**KIRKLEES METROPOLITAN COUNCIL
INVESTMENT & REGENERATION SERVICE**

DELEGATED DECISION TO DETERMINE PLANNING APPLICATIONS

Reference No:	2024/62/90331/E
Site Address:	105, Marsh Lane, Shepley, Huddersfield, HD8 8AP
Description:	Erection of garage and external alterations
Recommending Officer:	Edward Cheseldine

HOUSEHOLDER DELEGATED REPORT

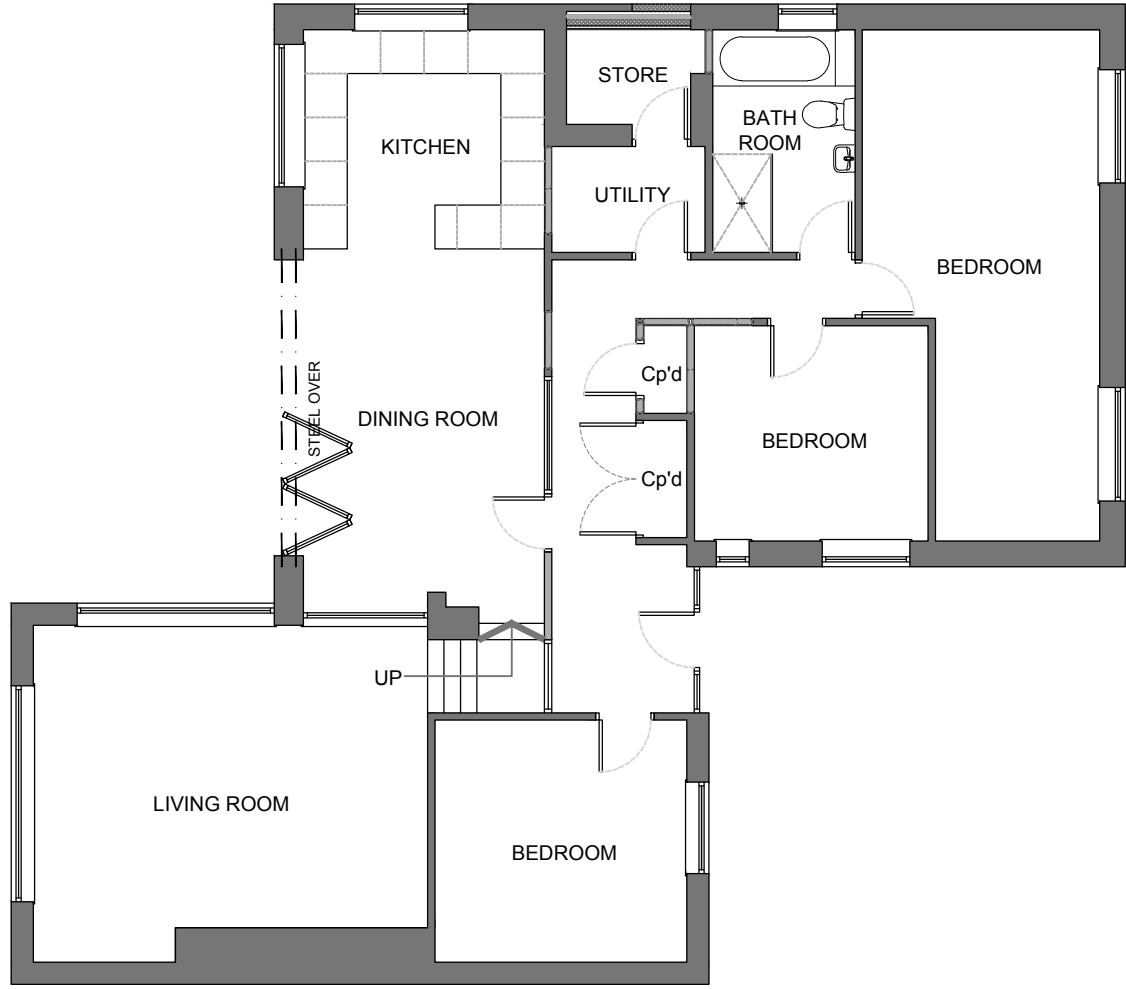
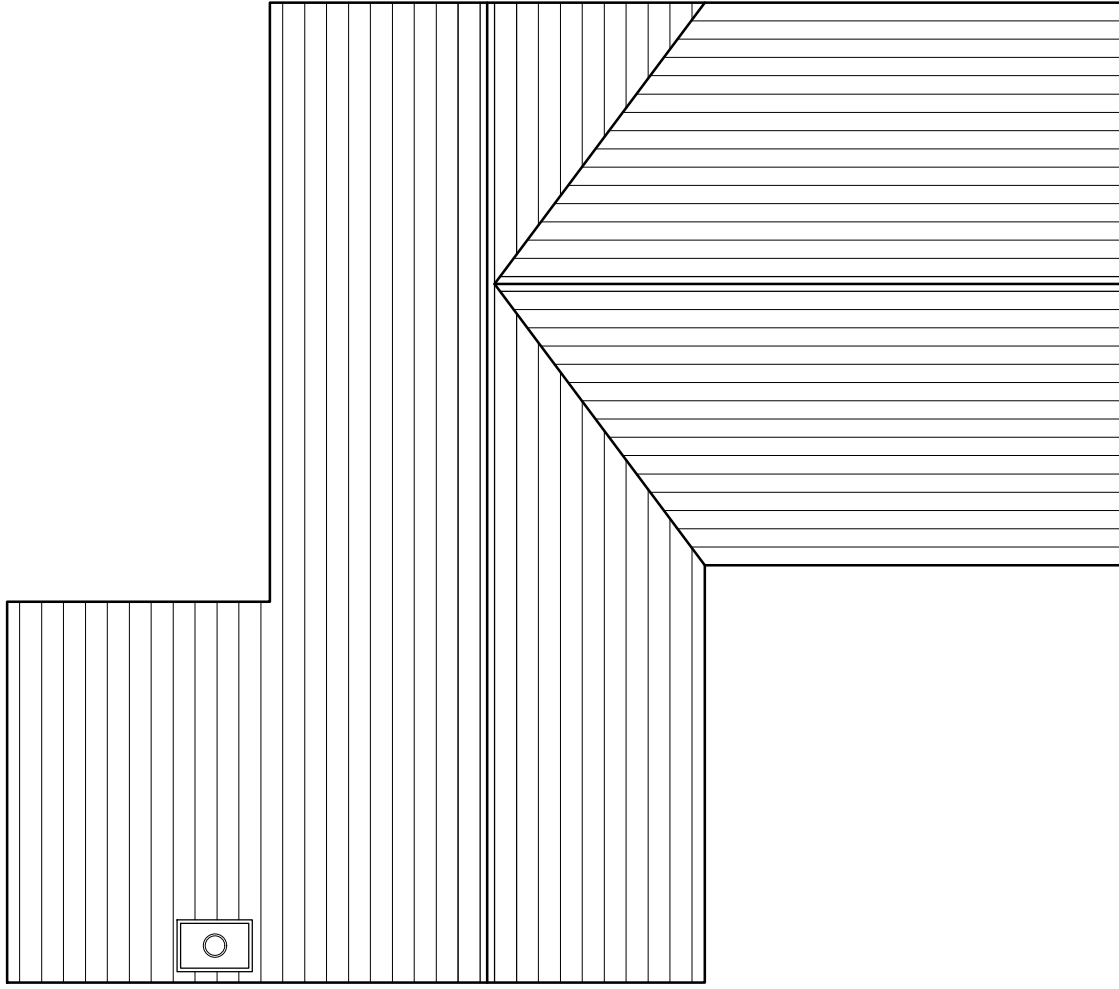
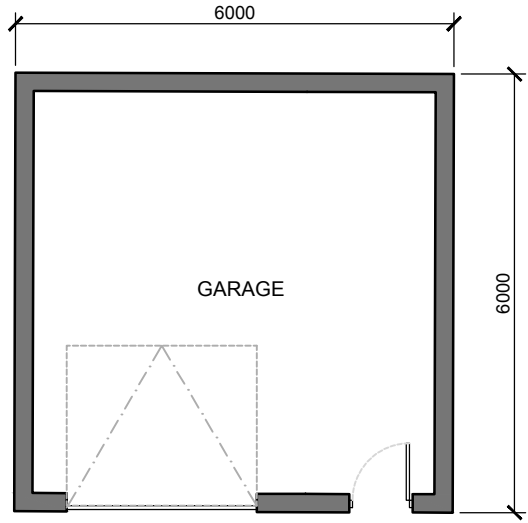
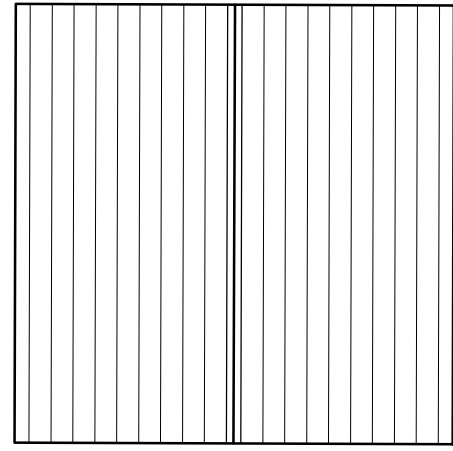
YES / NO	SUMMARY
Negotiations/Amendments during course of application		Yes, the garage has been set back in line with the adjacent properties, quoins have been added to the design of the garage. Fencing to the front of the property has been removed from the plans.
Parish/Town Council comments sought	No

extensions and existing outbuildings		which contains a garage to the front of the property of a similar footprint to the proposed garage.
Be set back behind the building line of the original building so that they do not impact on the street scene		The site features a long front garden space. The position of the garage is set back adjacent to the extension of the neighbouring dwelling, No 107 so not to disrupt the building line at Marsh Lane.
Preserve a reasonable private amenity space appropriate to the potential number of occupants of the house, and follow a general principle that no more than 50% of garden space should be lost.	Private outdoor amenity space is situated to the rear of the property, this area will not be affected by the proposal. Over 50% of the garden space will remain.

be no impact to highway safety when entering/exiting the site.	
Parking provision	<ul style="list-style-type: none"> • KDP 15 of the SPD • Policy LP22 Parking (f) of the KLP • Chapter 12 of the NPPF 	The area currently used for parking will be covered by the garage. A space for parking will still remain to the side of the plot, whilst the garage is large enough to accommodate one vehicle. Given the number of bedrooms the number of parking bays is sufficient.	✓
Provision for waste storage	<ul style="list-style-type: none"> • KDP 16 of the SPD • Policy LP24 Design (d) (iv) • Chapter 12 of the NPPF 	Bin storage for the dwelling is currently to the front of the house as such, adequate room will remain.	✓
